Application Ref:	3/2026/0159			 Ribble Valley Borough Council <small>www.ribblevalley.gov.uk</small>
Date Inspected:	17/03/2026	Site Notice:	17/03/2026	
Officer:	MC			
DELEGATED ITEM FILE REPORT:				REFUSAL

Development Description:	Permission in principle for up to 3 no. self-build dwellings to include 1 no. bungalow for over 55's.
Site Address/Location:	Land off Shire Lane (adj Shire Lane House), Hurst Green, BB7 9QR

PROPOSED ELEVATIONS

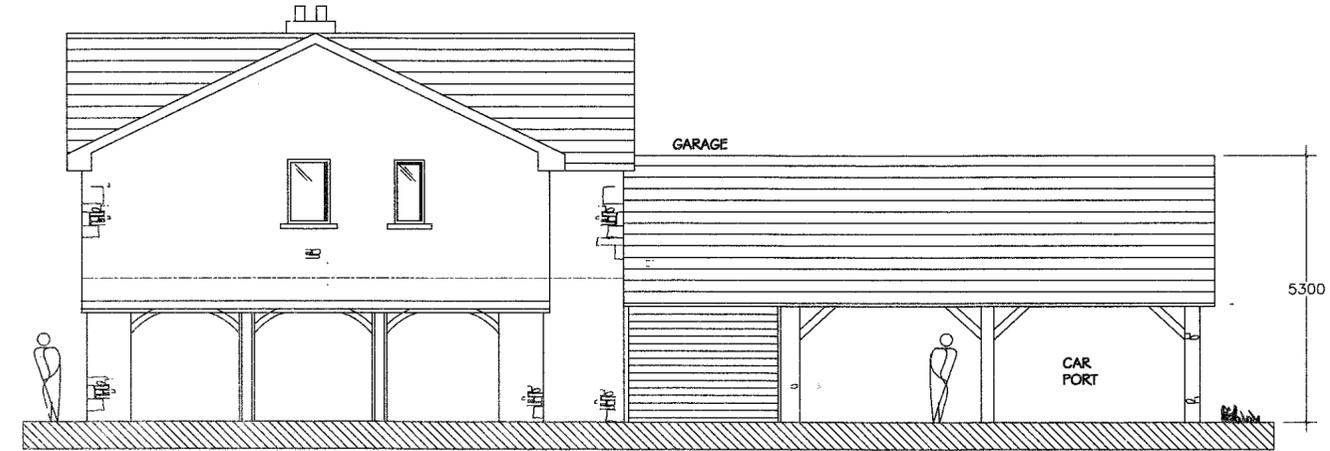
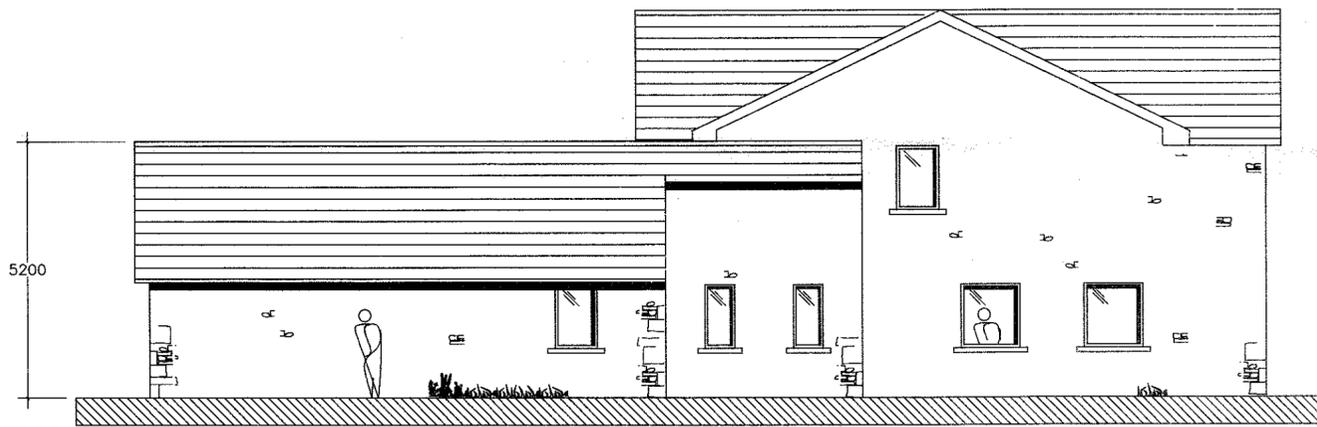
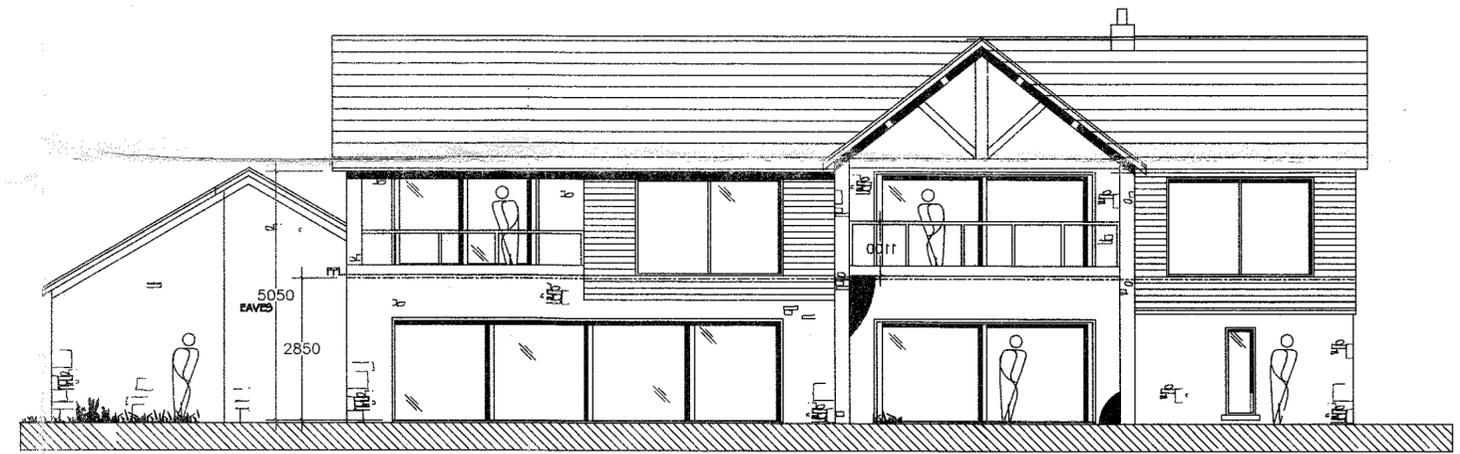
In this instance permission in principle is sought for the development of up to three dwellings within the application site. The application has not been supported by any indicative site plan. However, indicative elevations have been provided which show large two storey dwellings with a maximum height of 8 metres, including gable features and first floor balconies.

The indicative dwellings are considered to be of such a size and scale that would result in adverse impact to the natural beauty of the Forest of Bowland National Landscape. Notwithstanding the above, even if a differing size of dwelling were to be considered if the application were to progress to ‘technical matters’, it is not considered that the introduction of three dwellings within the rural landscape of the Forest of Bowland National Landscape would be acceptable, as the site currently maintains open, countryside views. The introduction of three dwellings in this location, along with the associated hardstanding for driveways/parking and introduction of gates/walls fences to separate the residential curtilages that would form part of such residential scheme would result in a harmful urbanising impact, diminishing the natural beauty of the Forest of Bowland National Landscape.
